**ADC Planning Consultation
Response from the Historic Buildings Adviser**

Application Number	BR/262/13/L
Address	Manor House, 12 Chichester Road, Bognor Regis, PO21 5BP
Description	Application for Listed Building Consent for conversion of existing listed building currently vacant to provide 4no flats. Demolition of single storey building at rear and construction of single storey extension and separate 2 storey building to provide 5no flats (9 in total).
Case Officer	Peter Cleveland
Site Visit	Previous

Objection

DRAWING TITLE
PROPOSED ELEVATIONS
SHEET 1

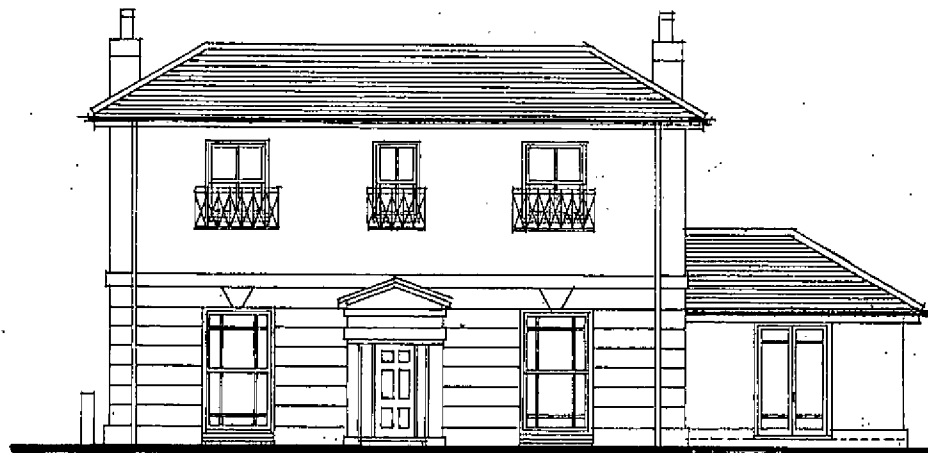
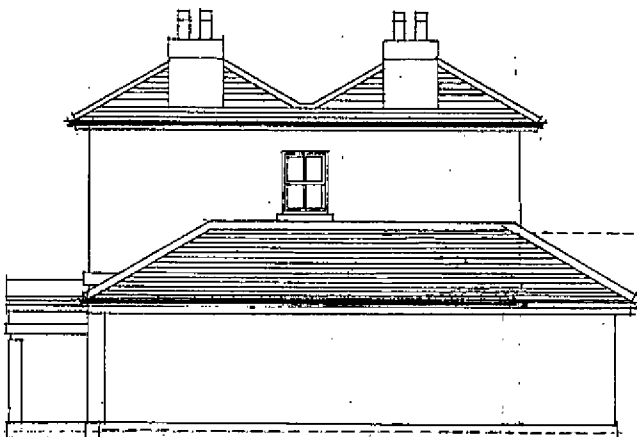
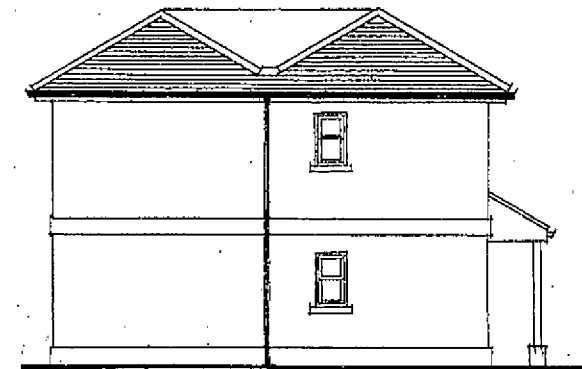
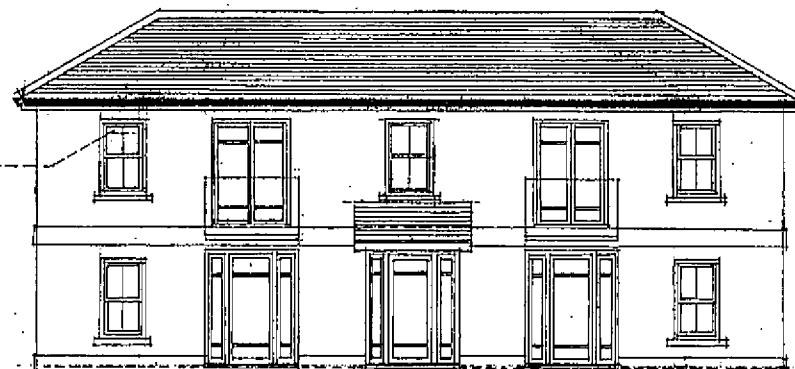
The proposed addition to the side, whilst subservient in height, has an excessive footprint which is not sympathetic with the listed building or its plan. The large area of flat roof is also inappropriate.

The development of the extension to the rear into a two storey block of flats is also not acceptable. Whilst a single-storey addition may have been justified in providing a care facility, this broader public benefit is not relevant here. The new proposal instead represents overdevelopment within the setting of a listed building - one that directly competes with it in terms of both scale and massing. Para 132 of the NPPF advises authorities that 'when considering the impact of a proposed development on the significance of a designated heritage asset, great weight should be given to the asset's conservation..... Significance can be harmed or lost through alteration or destruction of the heritage asset or development within its setting.'

CLIENT
CS PROPERTY AND CONSULTANCY LTD
PROJECT
**MANOR HOUSE, 12 CHICHESTER ROAD
BOGNOR REGIS PO21 2XE**
DRAWING TITLE
PROPOSED GROUND FLOOR PLAN
SCALE
1/100 at A3
REFERENCE
11332.05 A

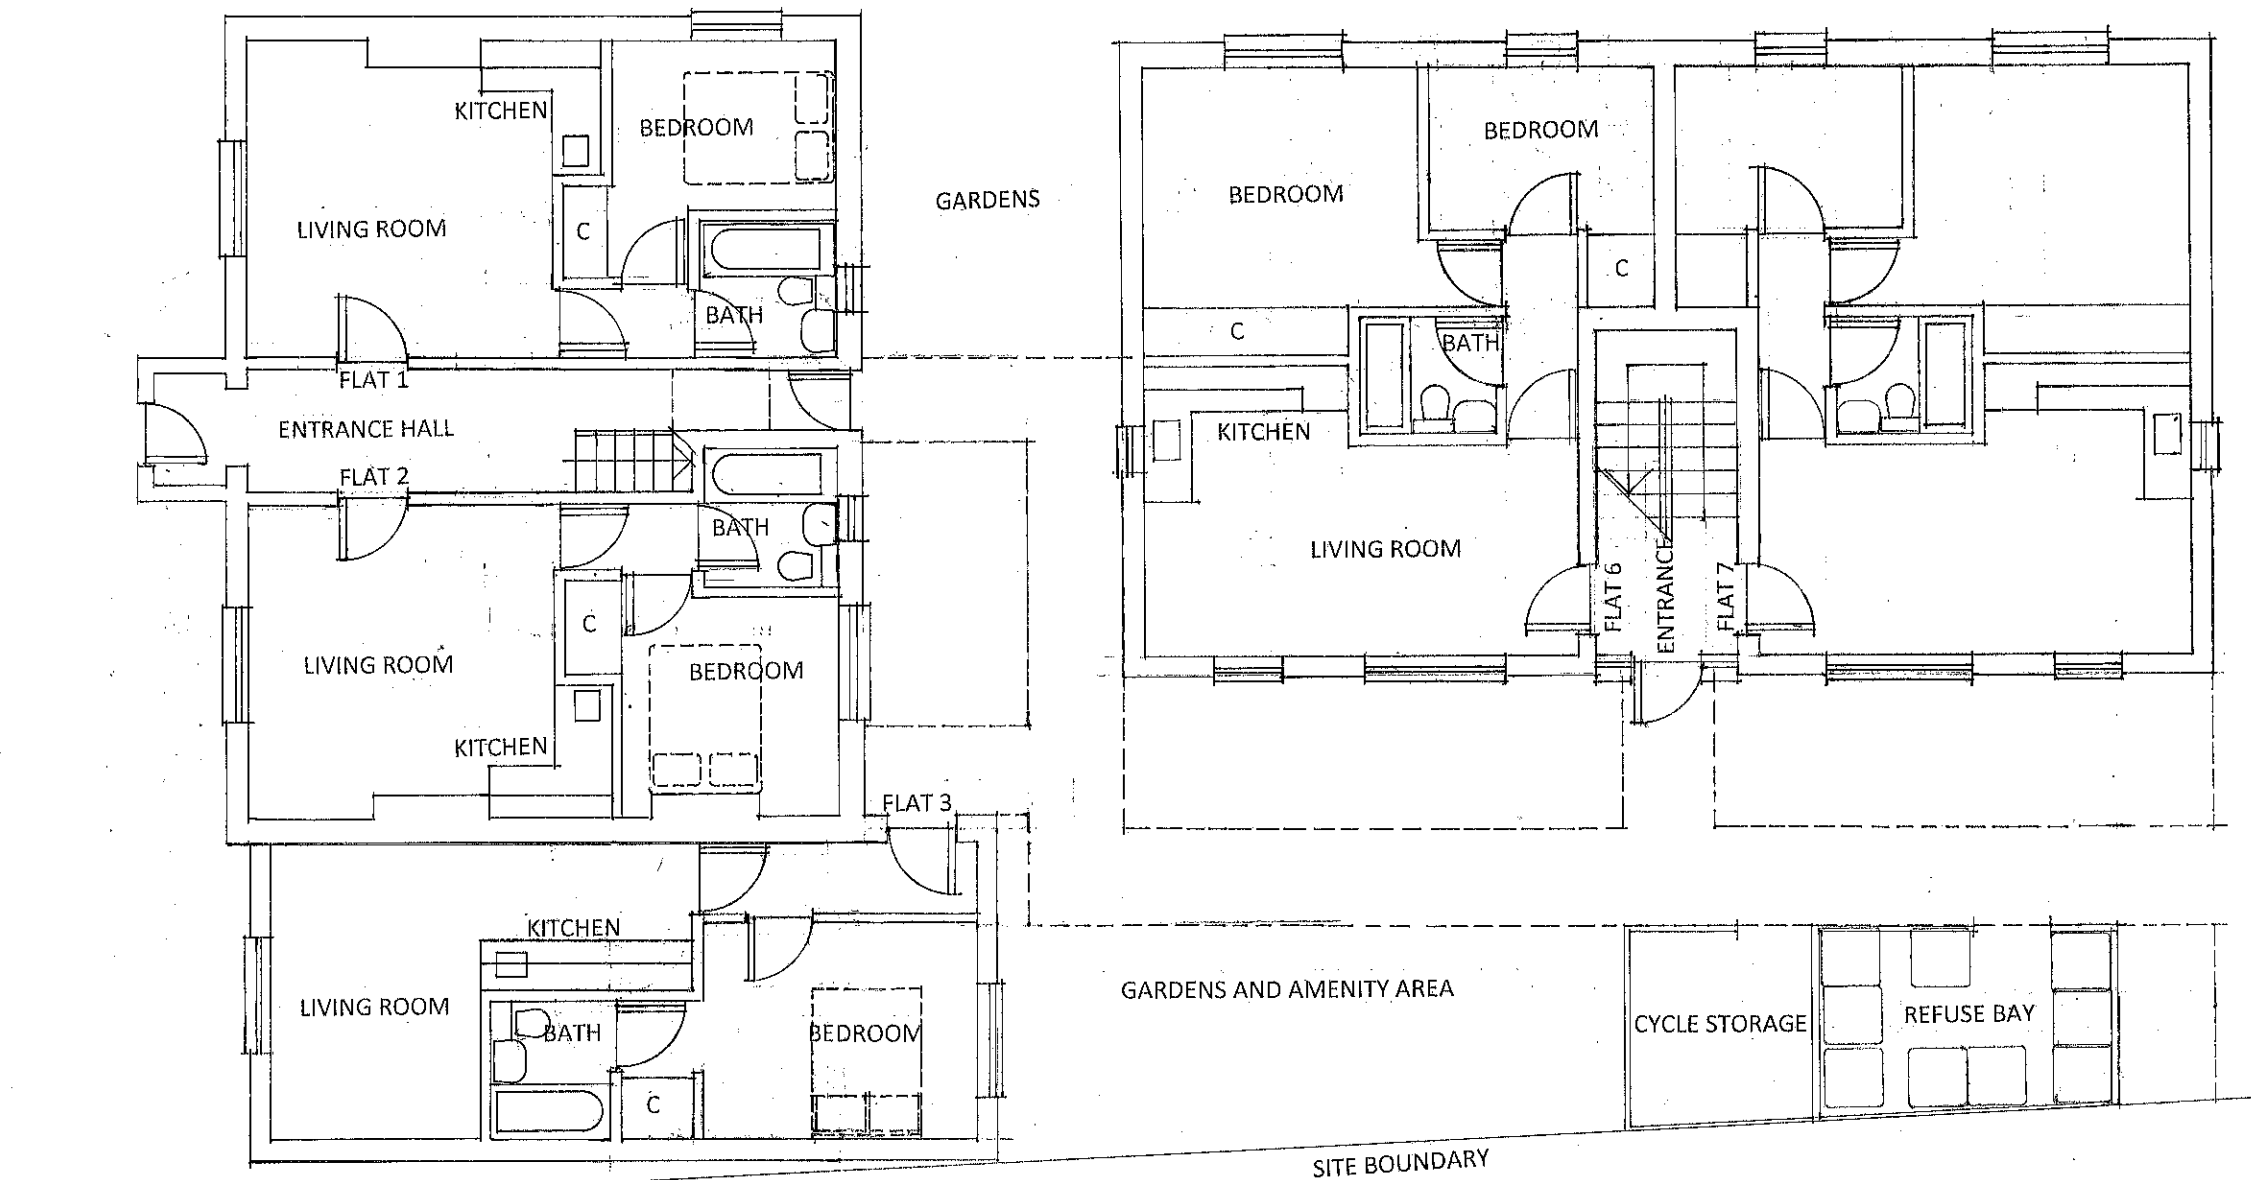
Internally the proposed alterations appear wholly unsympathetic, particularly as the building has a strong cellular plan. Whilst there may be some alteration here, the total disregard for the plan and the nature of the subdivision is extremely problematic. Authorities are required to protect the quality of
